**KIRKLEES METROPOLITAN COUNCIL
INVESTMENT & REGENERATION SERVICE**

DELEGATED DECISION TO DETERMINE PLANNING APPLICATIONS

Reference No: 2020/62/94086/W

Description: Erection of raised decking to front

SIDE ELEVATION

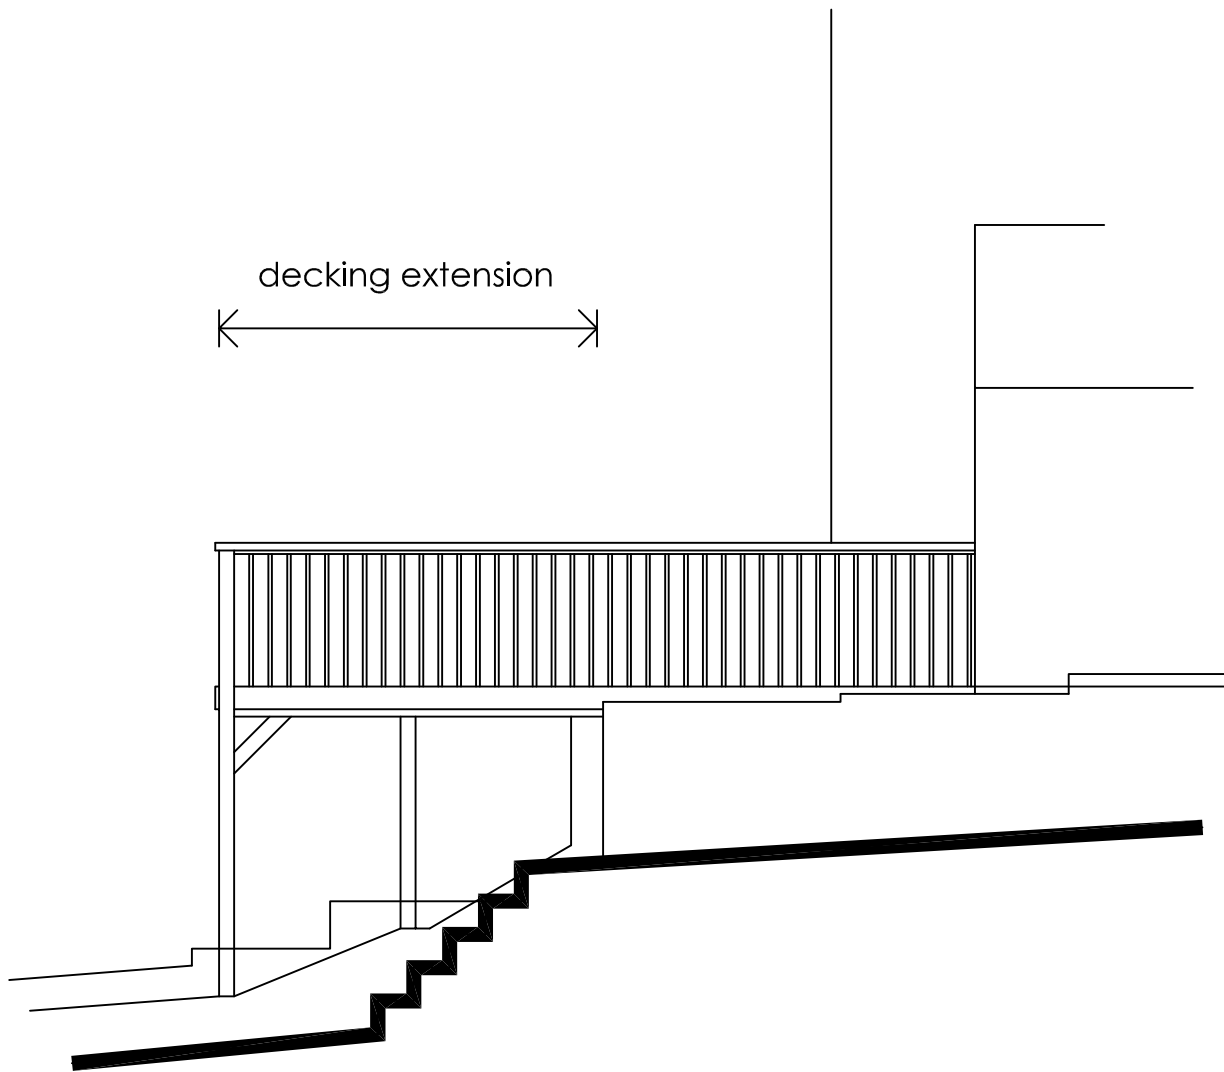
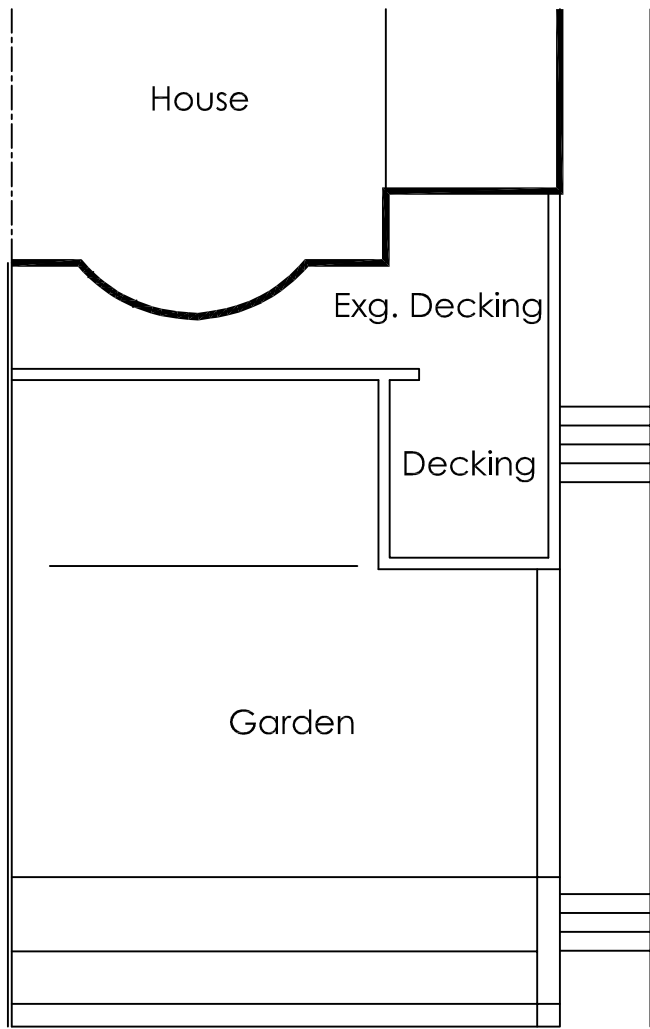
The decking is flush with the side elevation of the existing decking and projects forward by 2.5 metres on the side elevation facing No. 40 and is a width of 2.4 metres. The total height of the projection is 2.4 metres with the balustrade above being a total additional height of 0.9 metres. The materials of construction match those of the existing decking.

Due to the siting of the extended section of decking, the property mainly affected by the development is No. 40. It is noted that there are a number of enlarged terraces within the street scene of varying sizes and styles. With regards to this development, the layout of the site and adjoining site are unique in so far as the neighbouring property has been extended up to the boundary of the plot and therefore is closer to application site than the layout of other properties within the street scene, being less than 1 metre in separation. As the decking projects forward of the building lines of the application site and neighbouring property and is at the same height as the finished floor levels of these properties, this gives rise to overlooking at close quarters to the habitable room window in the neighbouring property, to the detriment of the occupiers of this property.

In terms of this application, Officers have considered screening along the side elevation of the decking however due to the proximity of the decking to the neighbouring property, this would result in an overbearing feature close to the openings of the neighbouring property. Whilst it is noted that the neighbouring property is set on a lower ground level, due to the decking being at finished floor level and the balustrade being limited to 0.9 metres in height, it is not considered that the development would cause significant overshadowing.

It is therefore considered that the development would have an unacceptable impact on the adjacent neighbouring property, contrary to Policy LP24 and principle 3 of the Council's adopted House Extensions & Alterations SPD.

Due to its siting the decking results in an unacceptable level of overlooking resulting in a loss of privacy to neighbouring occupiers, contrary to Policy LP24 (b) of the Kirklees Local Plan, Key Design Principle 3 of the House Extensions and Alterations SPD and paragraph 130 of the National Planning Policy Framework.

PLAN 1:50

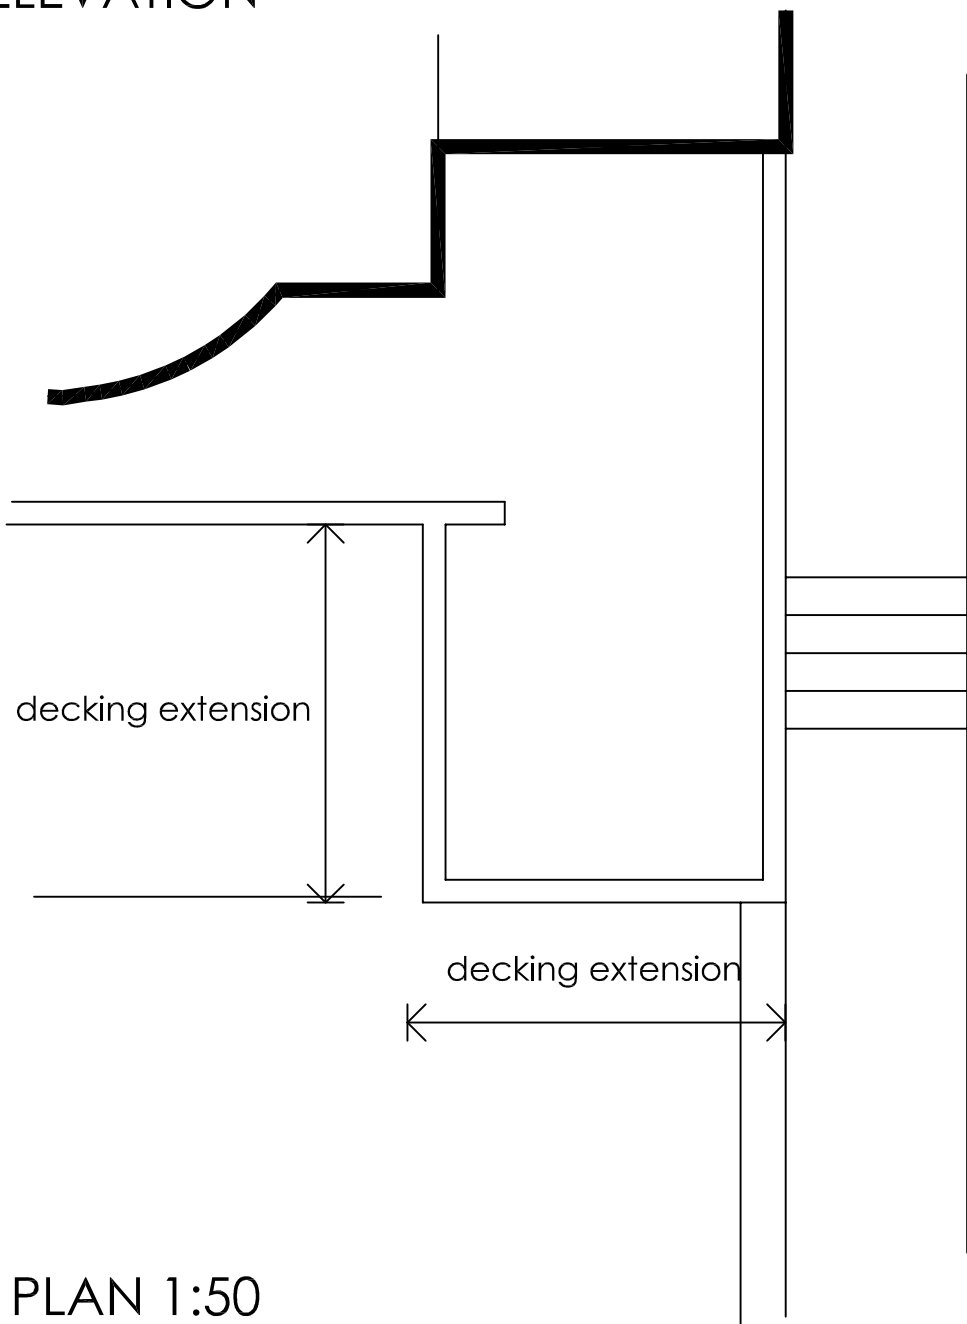
The decking is located on the front elevation of the property and comprises a total area of 2.5m x 2.4m, set in an elevated position due to the topography of the site. In terms of Policy LP57 sub-paragraph c states that an alteration to a property will normally be acceptable in the Green Belt providing that the development does not result in a greater impact on openness in terms of the treatment of outdoor areas, including hard standings, curtilages and enclosures and means of access.
